## **Appendix 9F**

### **Visual Impact of Southern Sidings**

Title:	<b>Viewpoint 16</b> View from properties on A4109	HFoV (°):	90	Visualisation type:	1	View direction:	North
Date, time:	3 December 2019, 11:31	Scale/ Enlargement factor:	96% at A1	Projection:	Cylindrical	Camera (lens):	Nikon D750, FFS (Nikon 50mm)

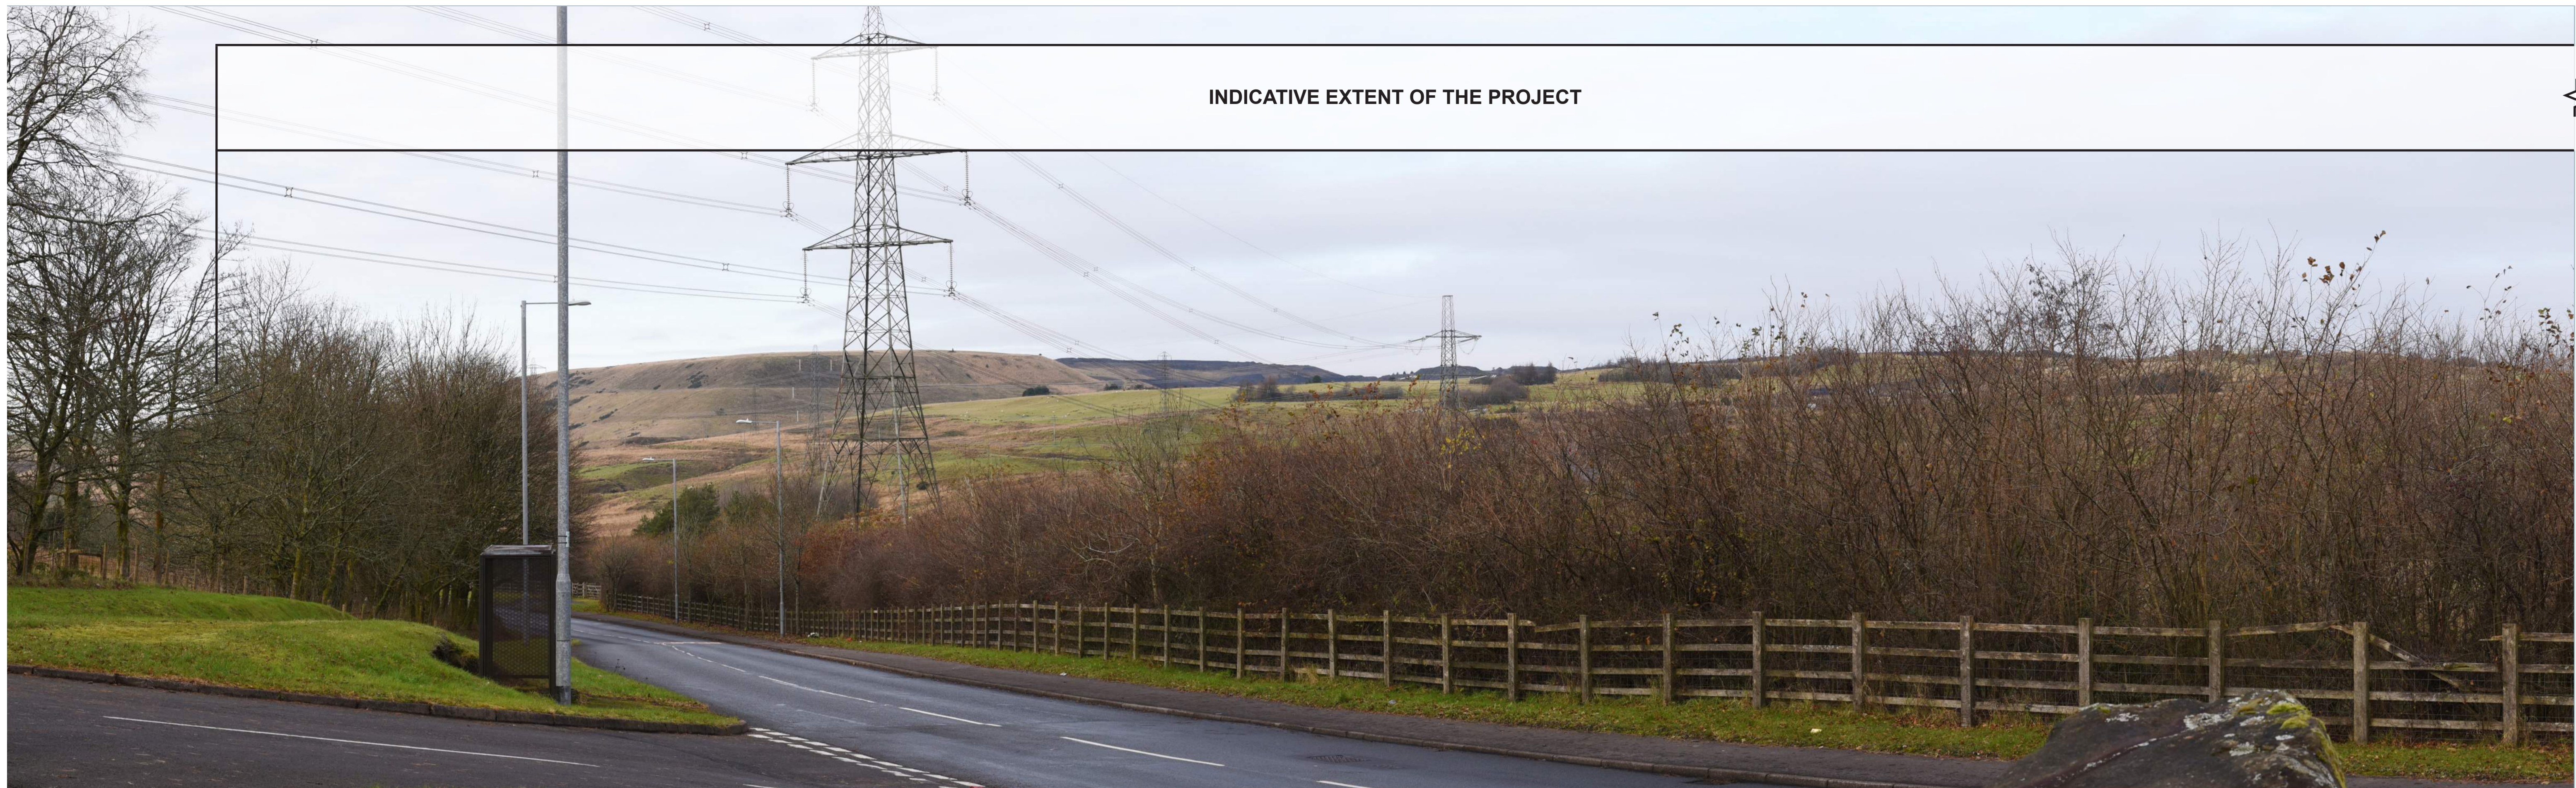
During consultee meetings held on 27/10/20 and 08/02/21 Neath Port Talbot Council felt that the full extent of visual impacts as a result of the sidings at the southern extent of the proposed development was not captured within the LVIA or fully understood. The area had not been specifically identified within the assessment due to restricted visibility in that part of the site, the existence of existing rail infrastructure and the proximity of other viewpoints.

The LVIA chapter includes Viewpoint 16 and Viewpoint 17 which are located to the south of the proposed development and capture the likely effects for receptors along the A4109. It was however agreed that additional supporting information would demonstrate how the sidings sit within the existing landscape.

The topography and existing vegetation provide screening of the majority of the sidings for receptors located along the A4109. Properties at the western edge of the sidings would have views of the acoustic barrier and passing trains, however, it is not anticipated to result in further significant effects beyond those reported at Viewpoint 16.

It is noted that rail and road infrastructure (A4109 and the Neath and Brecon Railway) forms part of the baseline condition for views from these properties and that mitigation measures such as screening planting would not be appropriate as it would result in a significant change to the long-distance nature of views that are currently available to the north.
